CITY OF ALBUQUERQUE

RE: **Green Jeans Farmery –**
3600 Cutler Ave NE, **Bldg 1 only** 87110

Grading and Drainage Plan (File: H17D036A)
Engineer's Stamp Date 2-10-2015
Engineer's Certification Date 9-15-15

Based on the Certification received 9/16/2015, the site is acceptable for a TEMPORARY 30-day Certificate of Occupancy by Hydrology.

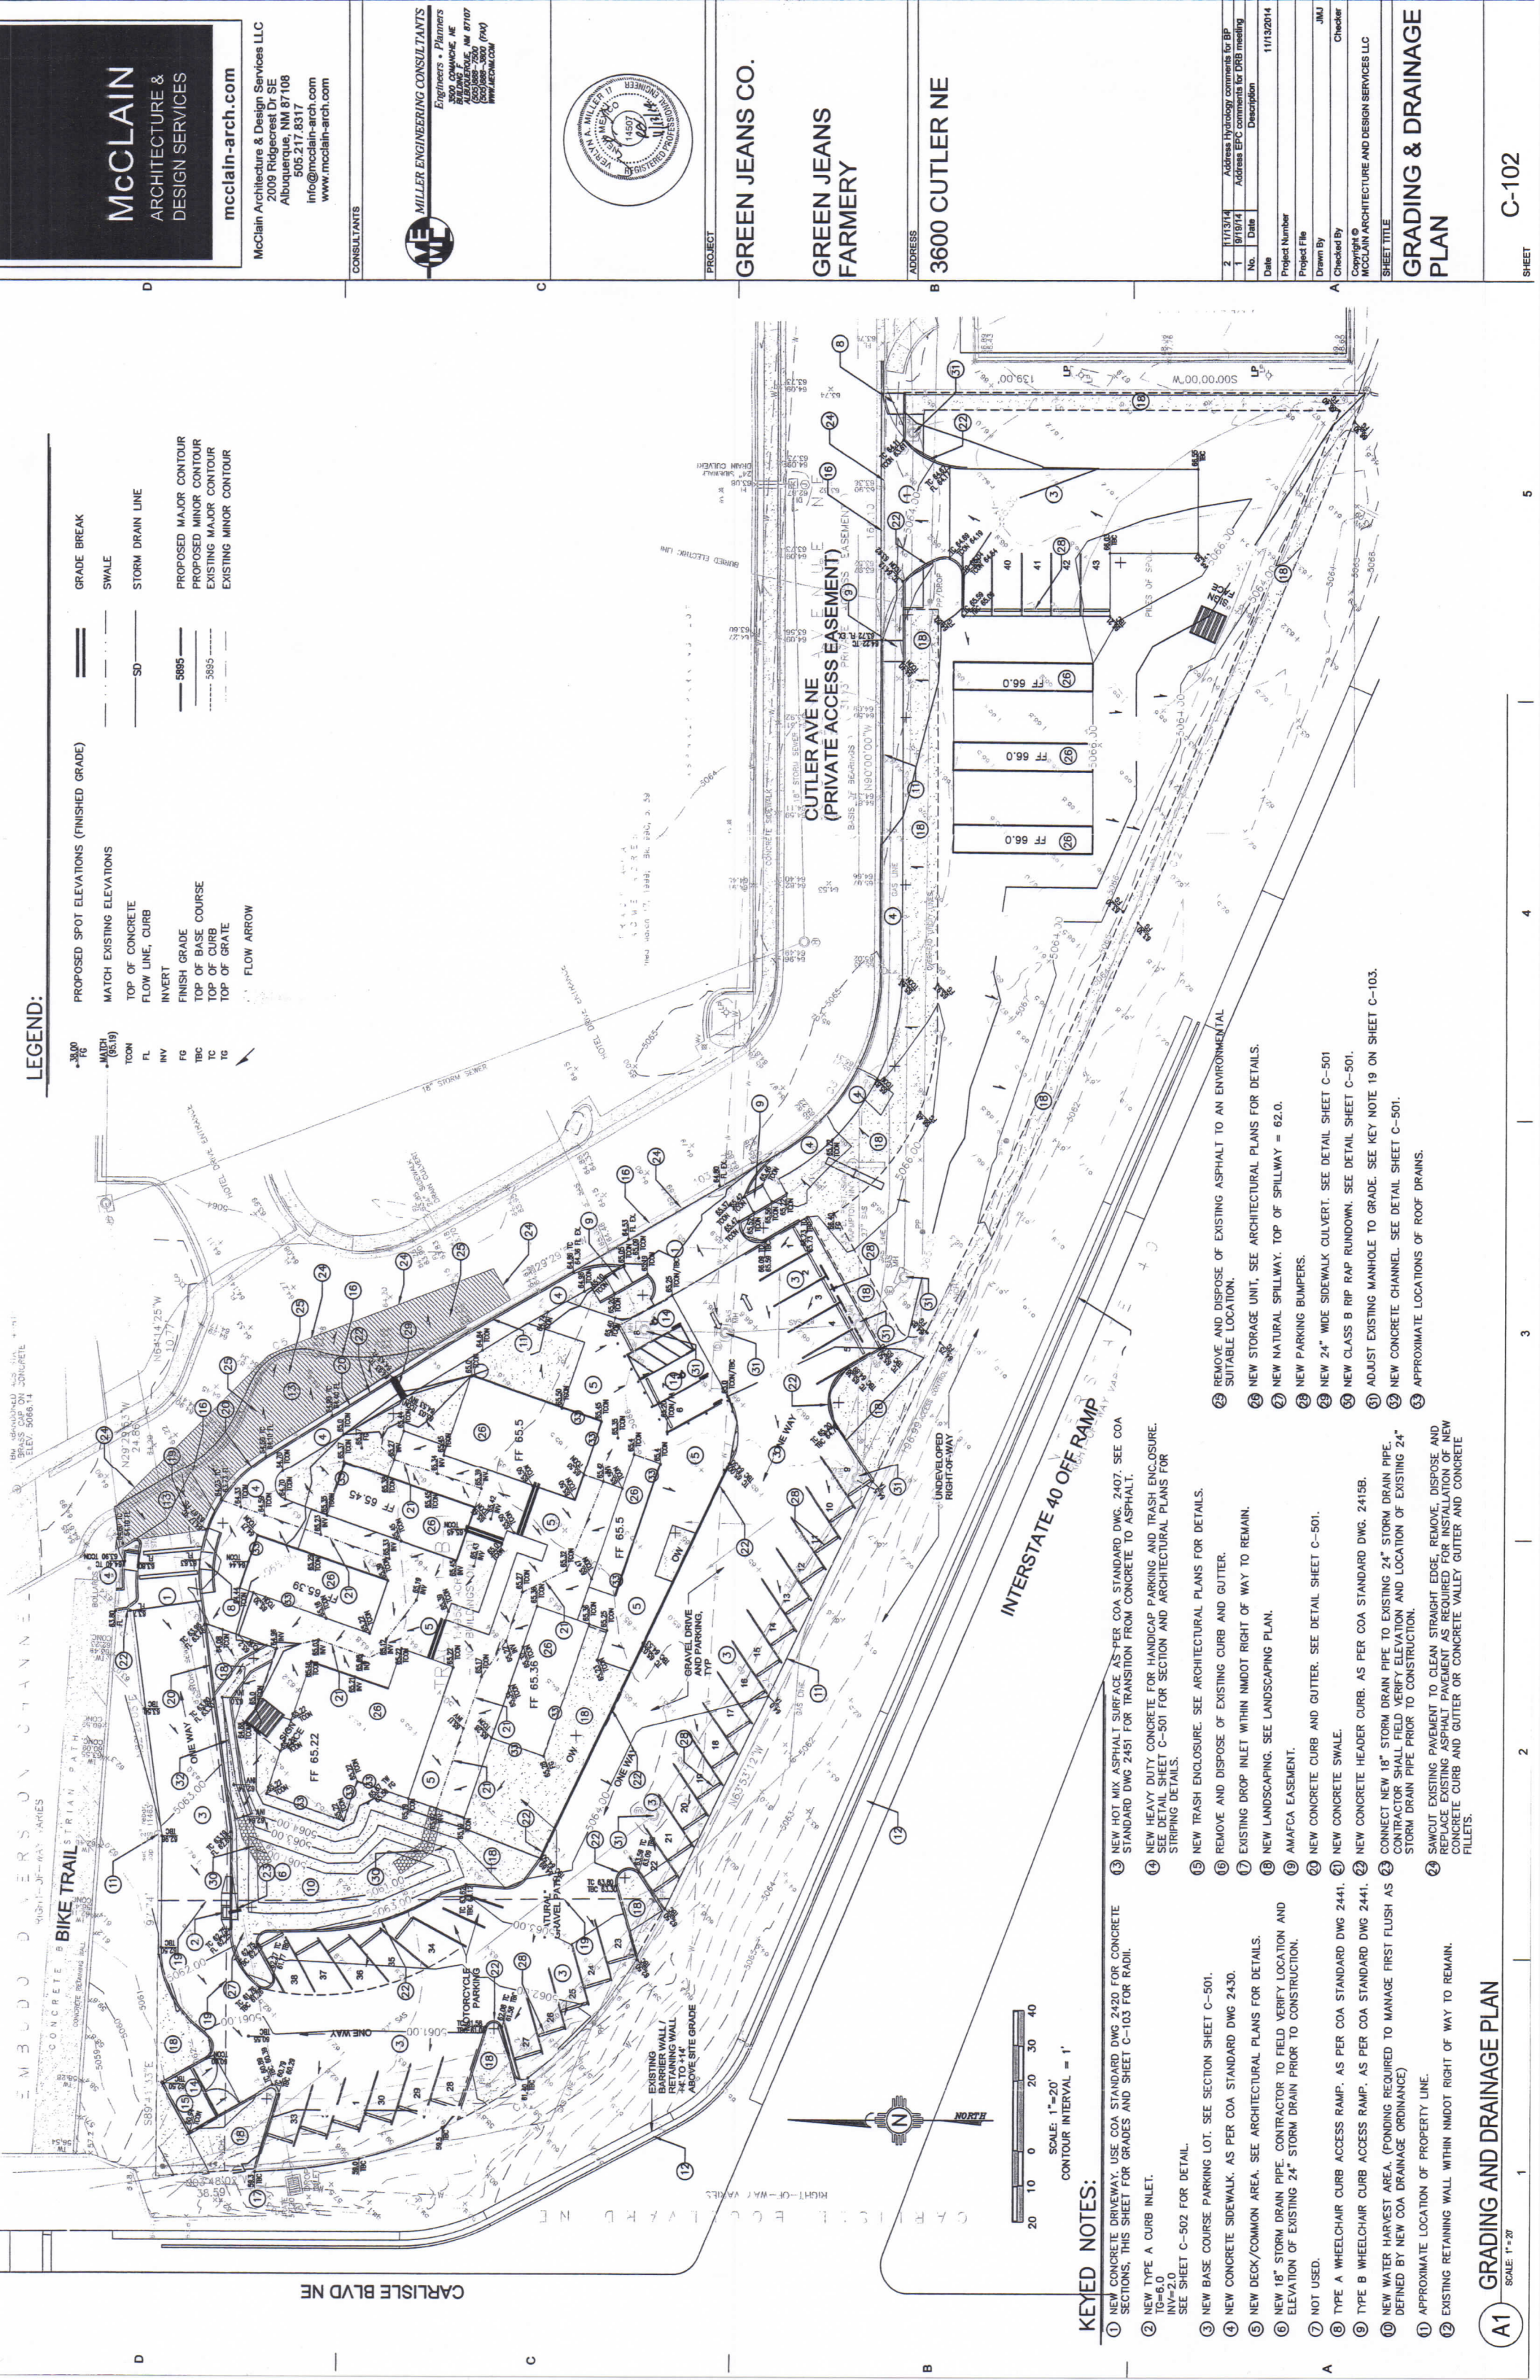
- 1) The slope tie along the southern boundary must be stabilized. (Western portion completed prior to Temporary C.O. including area around inlet)
- 2) Metal strips between parking bumpers to be modified to allow for drainage.
